REFUSAL OF PLANNING PERMISSION

APPLICATION NO. 2011/0151

Proposal Erection of 1 no. detached dwellinghouse (Resubmission)

At 32 Summer Lane, Royston, Barnsley, S71 4SE

Client
MR. P. J. ANDERSONProject
NEW GARAGE TO SIDE OF NO 32, SUMMER
LANE, ROYSTON, + NEW INFILL
DWELLING ADJACENTTitle
BLOCK/SITE PLANS, LAYOUT PLANS &
ELEVATIONS / SECTIONDrawn
JSTChecked
Scale
1:100 / 1:1250Project Ref.
PJA/R.Drawing No.
1/B

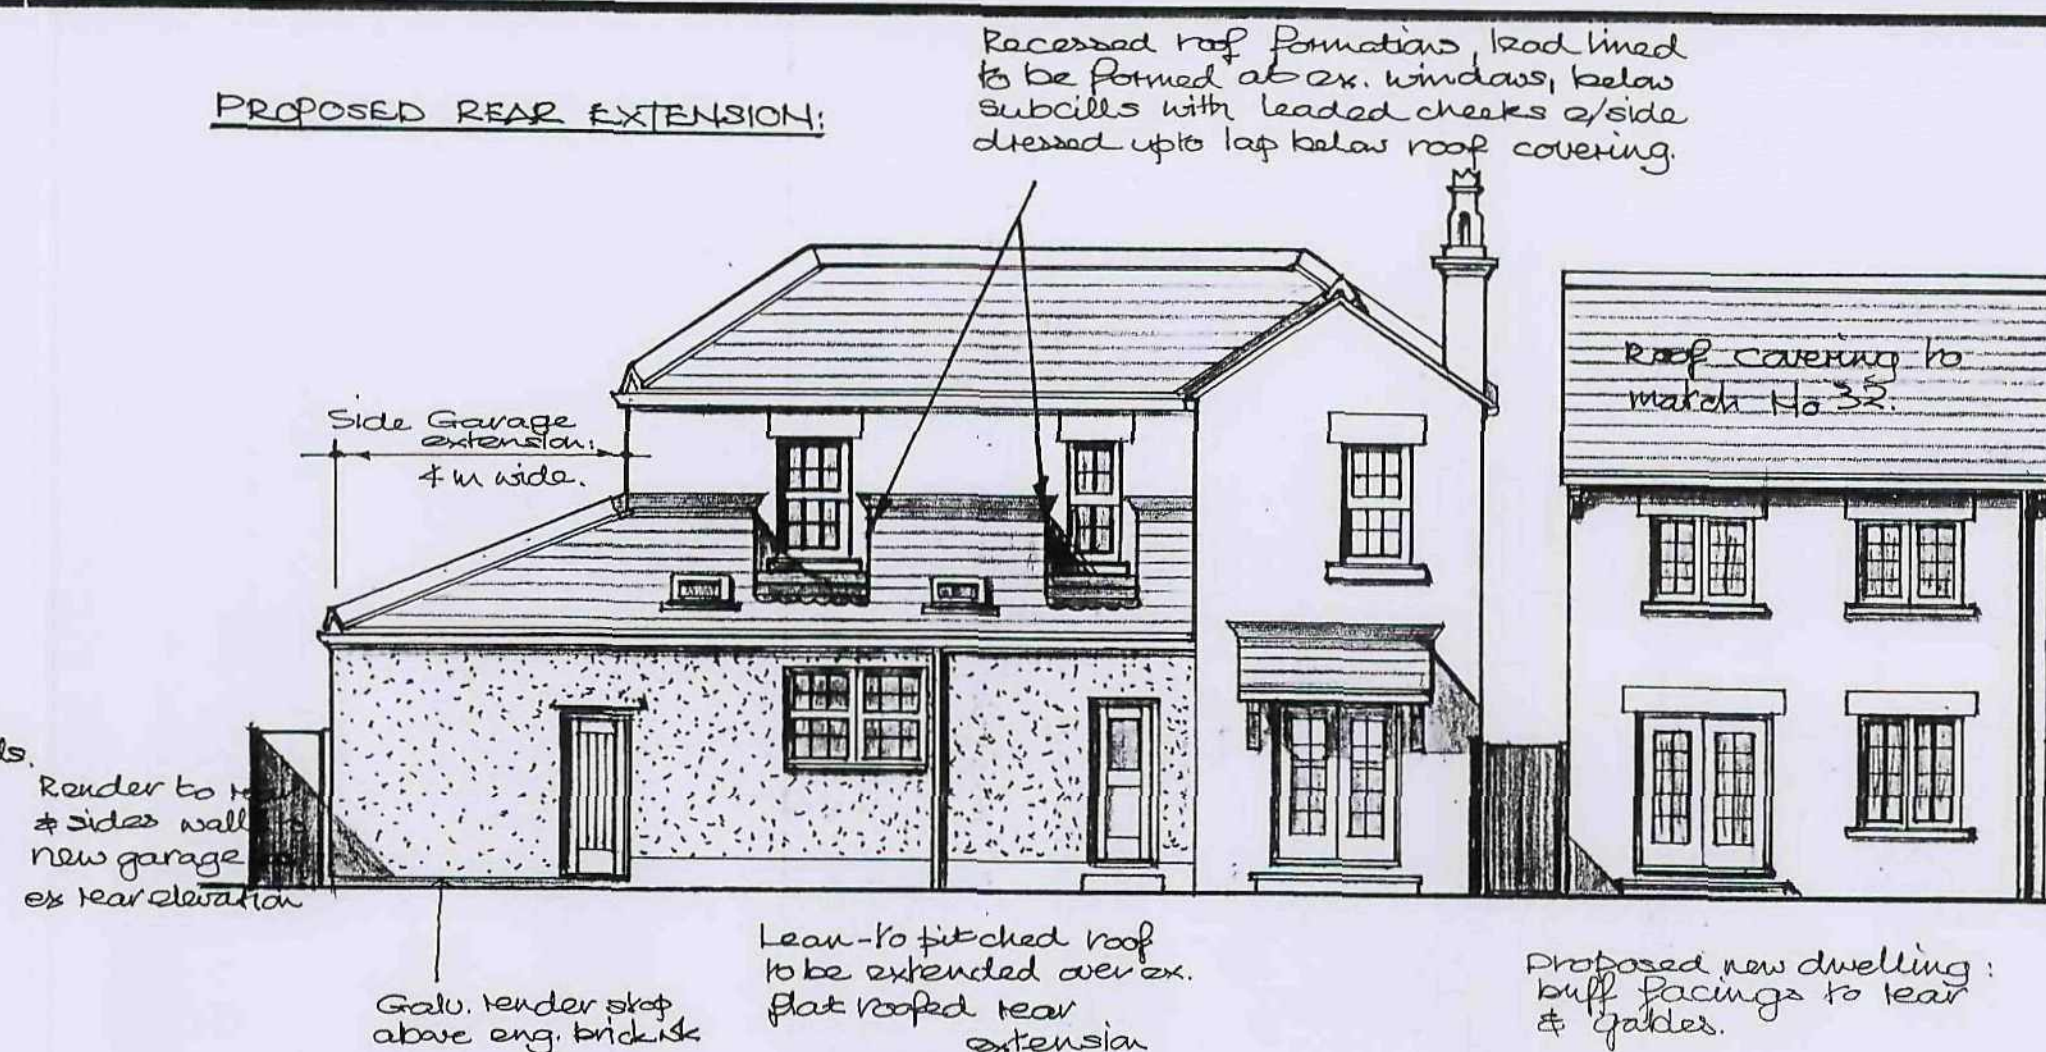
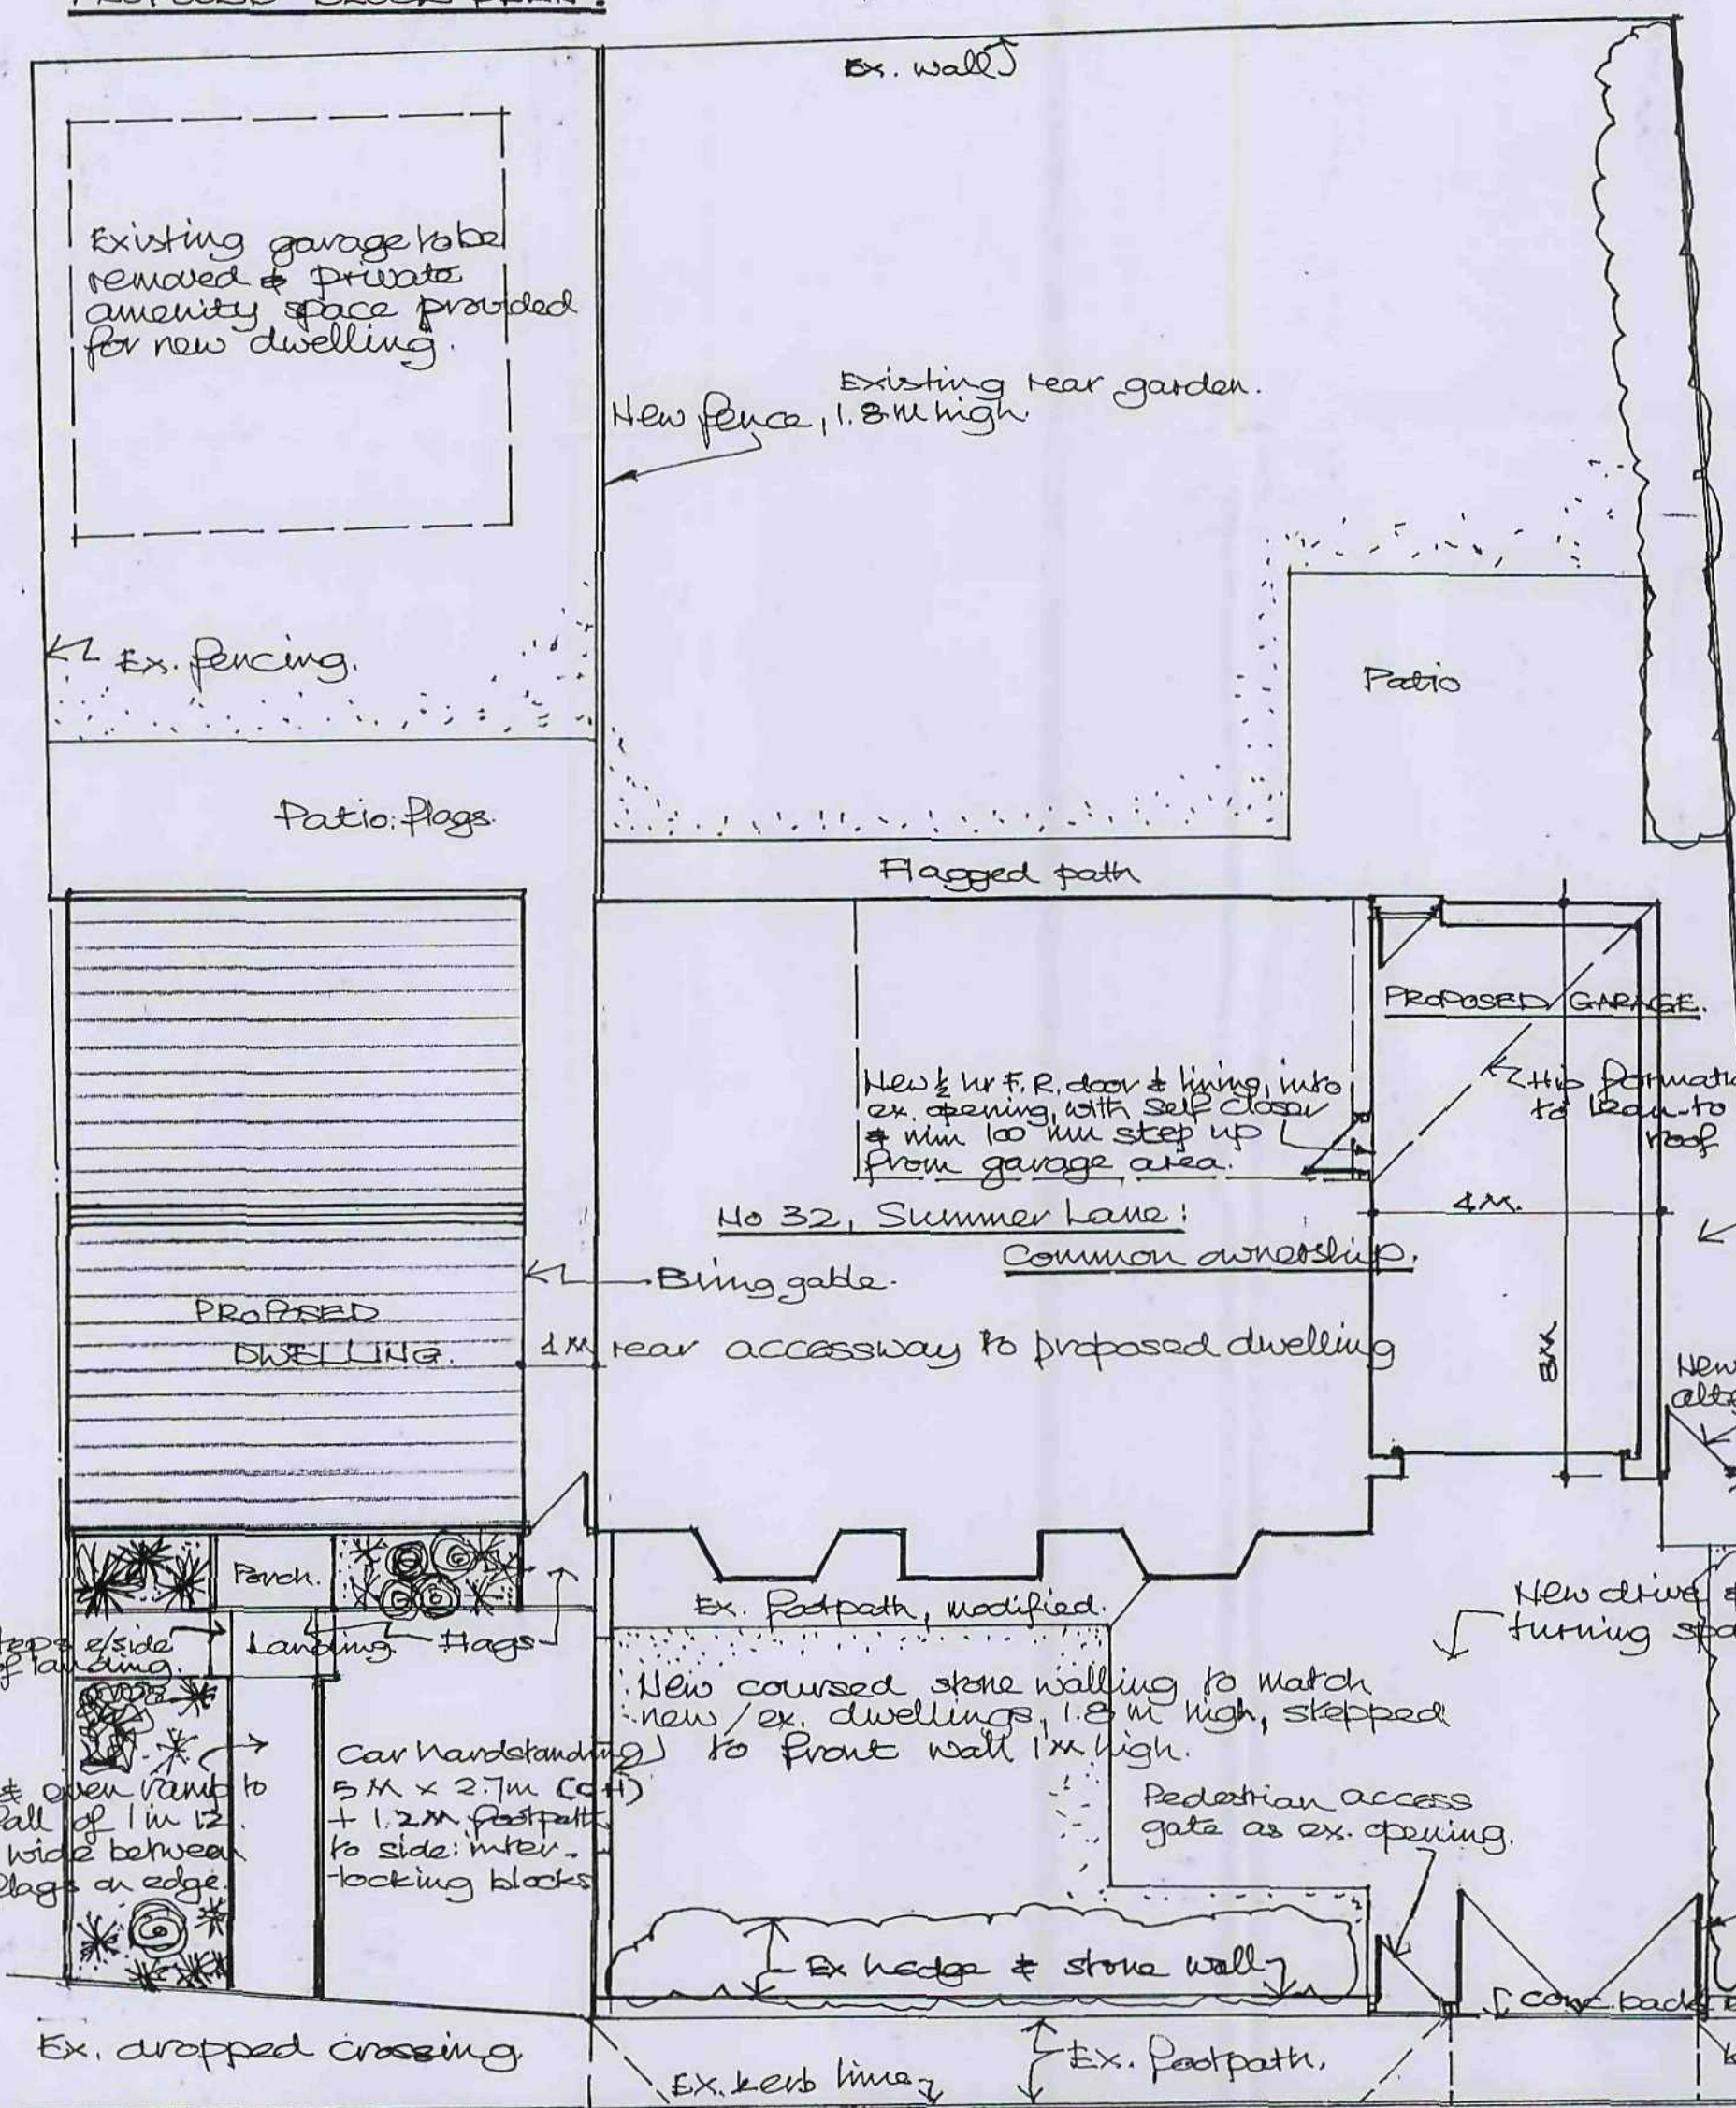
- 1 In the opinion of the Local Planning Authority the proposed dwelling would be contrary to Policy H8D of the Unitary Development Plan and the Council's Supplementary Planning Guidance Note 3 in that its position and design, in terms of the narrow plot and proximity to number 32 Summer Lane, would be architecturally inconsistent and not harmonise with the character of the adjacent properties. As a consequence of the above it would unreasonably affect the character of number 32 and would appear as an unduly intrusive feature in the street scene to the detriment of visual amenity.
